Landscape Plan Drawings_V1.pdf Markup Summary

WIRENUT
HOME SERVICES
6365 EAST PLATTE AVE.
EL PASO COUNTY, CO
PREPARED FOR:
HAMMERS CONSTRUCTION

CITY STAMP	JUMBER
	1082-22
REVISIONS	
ORIGINAL DATE	6-1-22
DRAWN BY	
DESCRIPTION	
LANDSCAPE PLAN	
SHEET NO.	L1.1

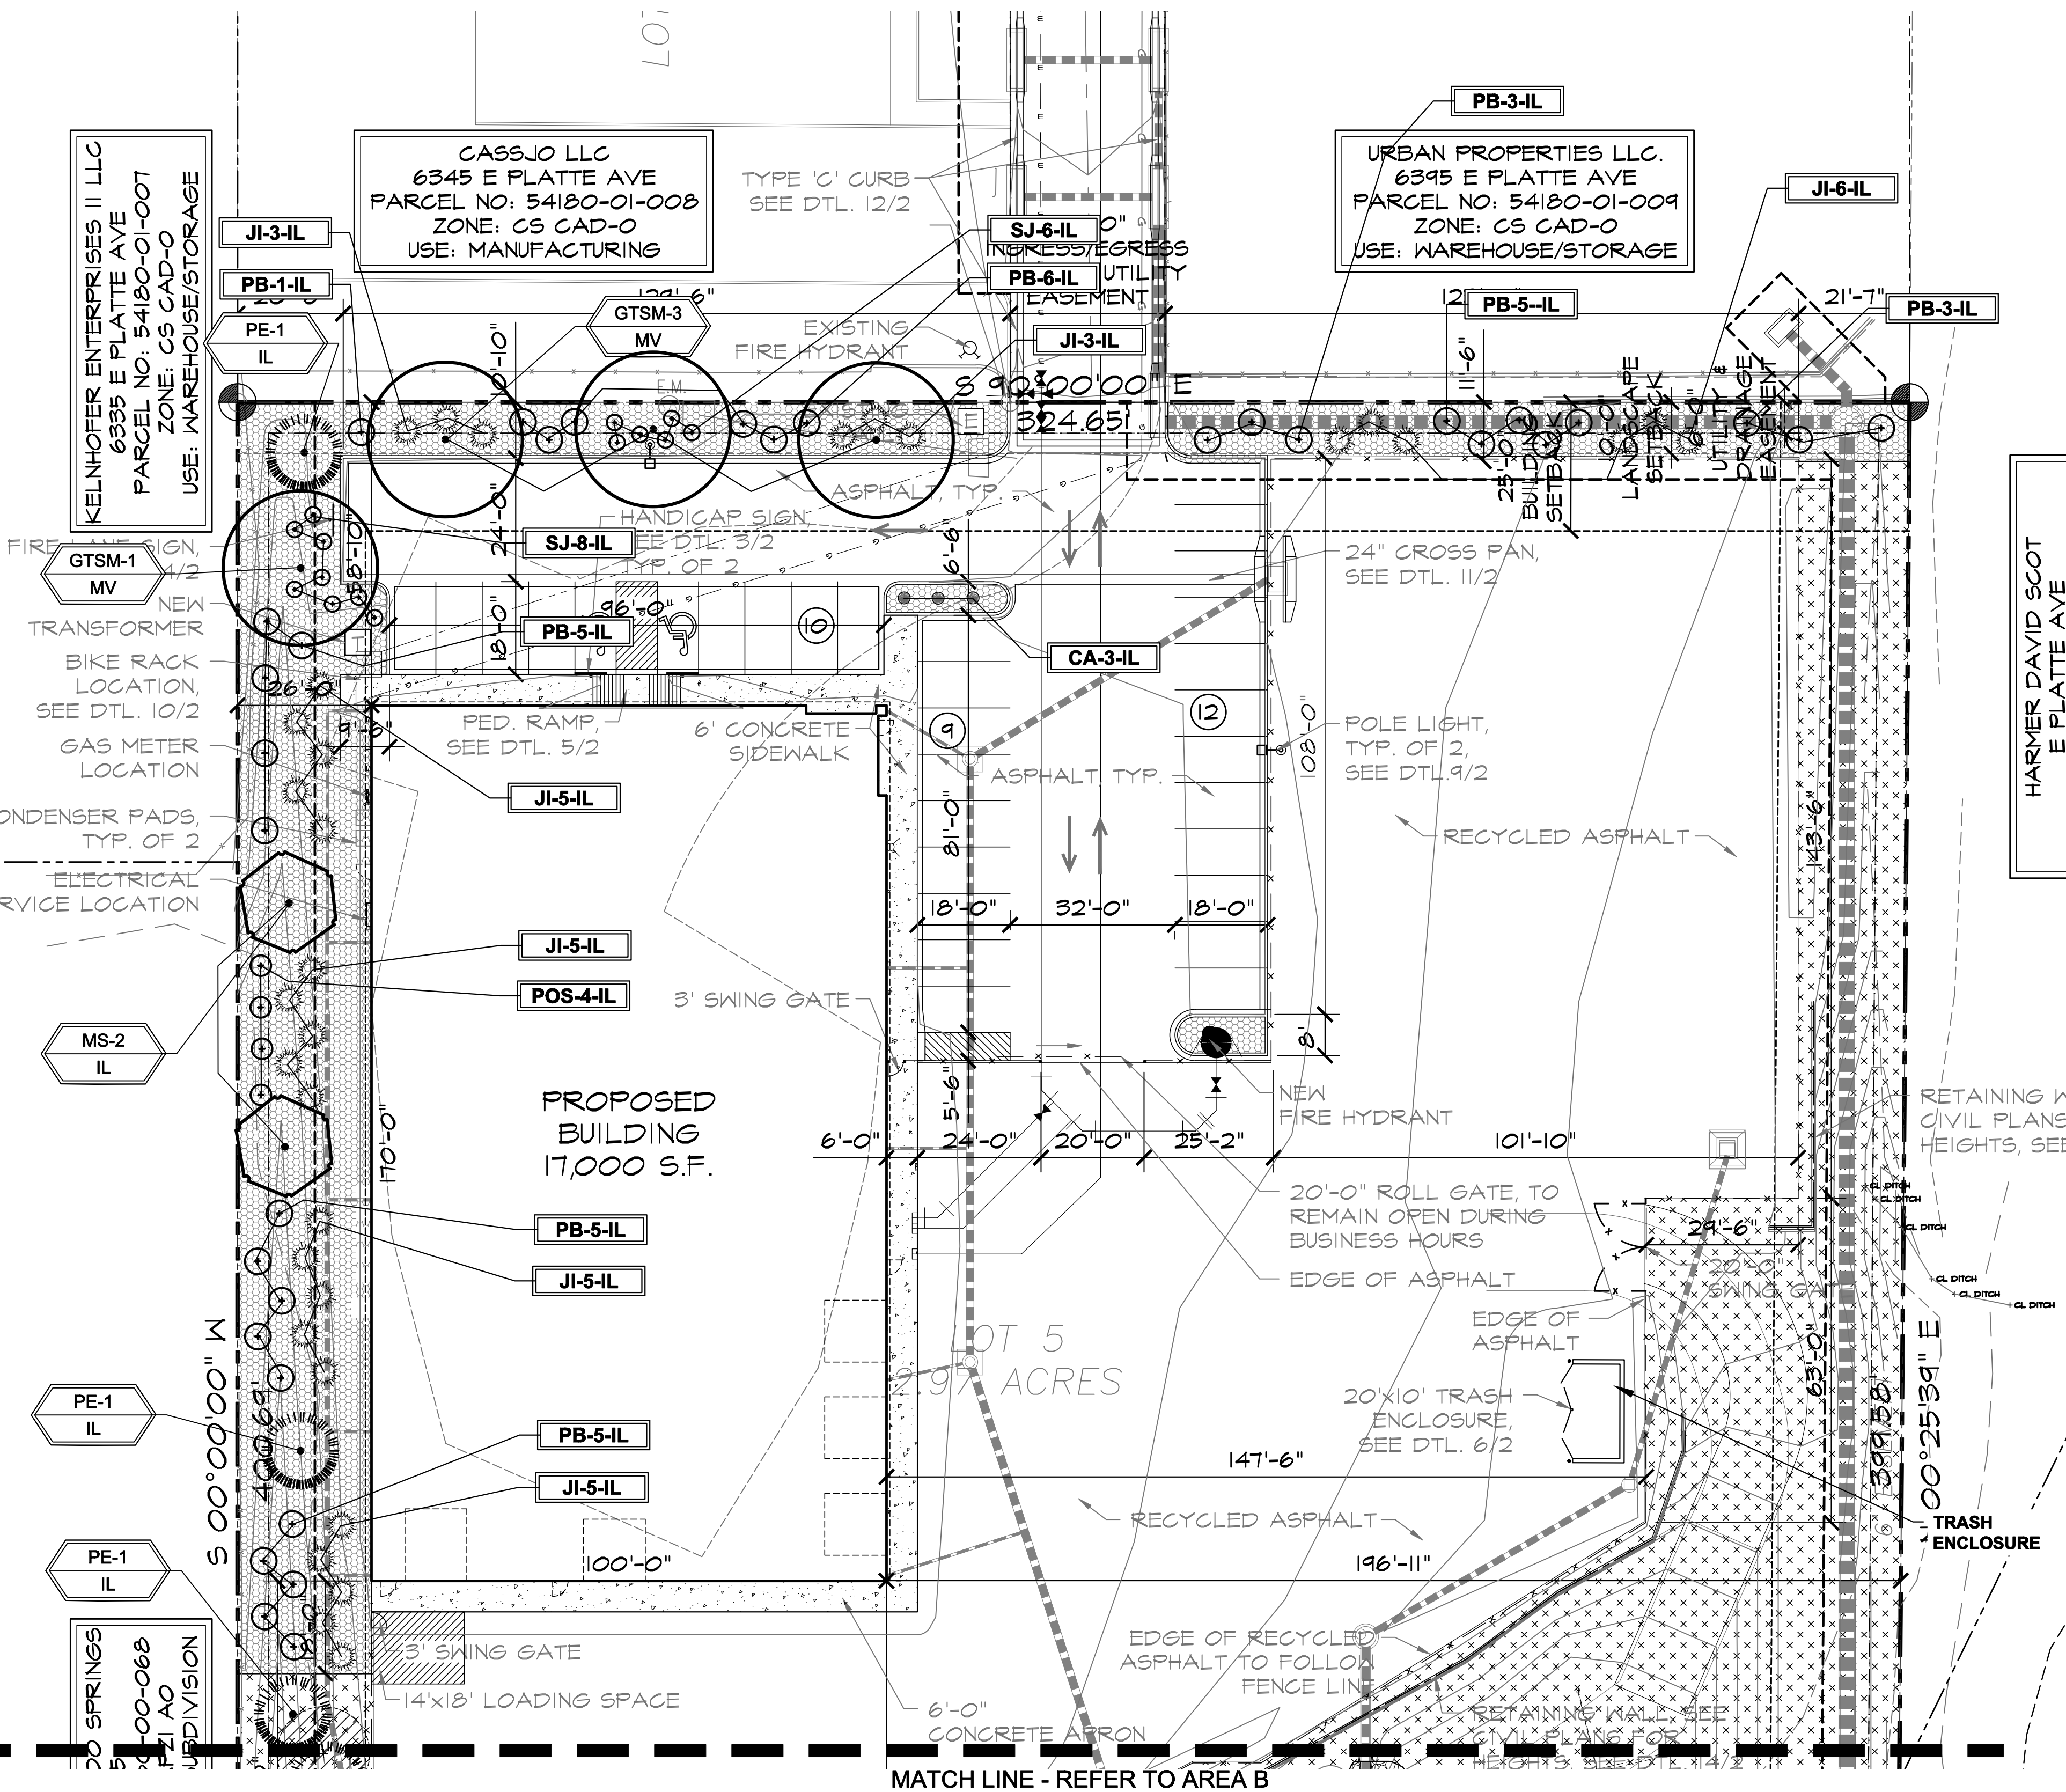
of spaces on this plan is less than the Site Development Plan

Proposed Building SF does not match Site Development Plan

Cannot complete a full review due to discrepancies in Landscape Plan & Site Development Plan. Please revise and resubmit.
